Submissions Report

Lot O, 200 Aldington Road, Kemps Creek

SSD-96107226 and SSD-10479-Mod-7

Submitted to the Department of Planning, Housing and Infrastructure
on behalf of Stockland Fife Kemps Creek Trust

Figure 15 Interim Stormwater management measures – (extract SKC228 for MOD7)

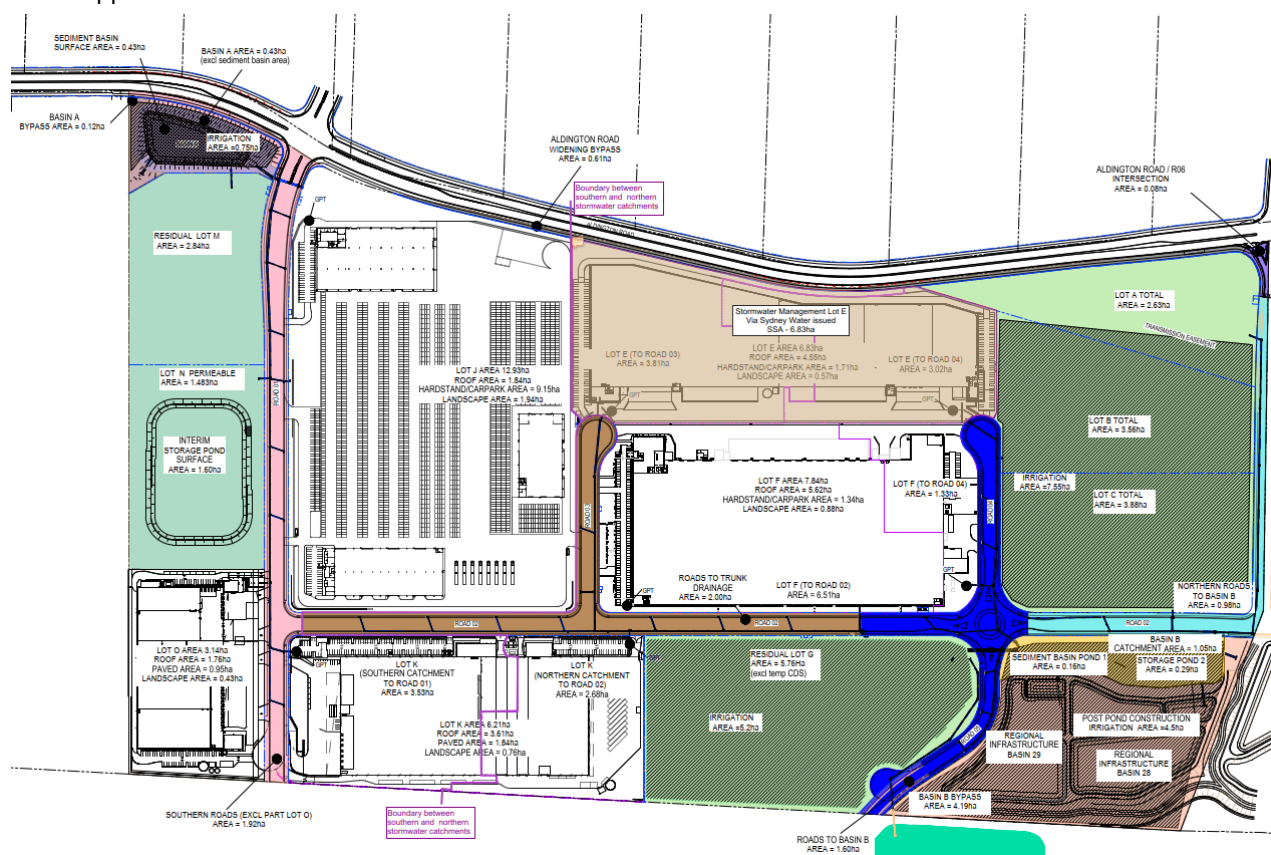
Southern Residual Lots Area (9.03 ha) in the legend of Stormwater Management Report, Appendix B, SKC228 should be updated.

An updated to SKC228 is provided within the Amended Stormwater Management Report (**Appendix C**).
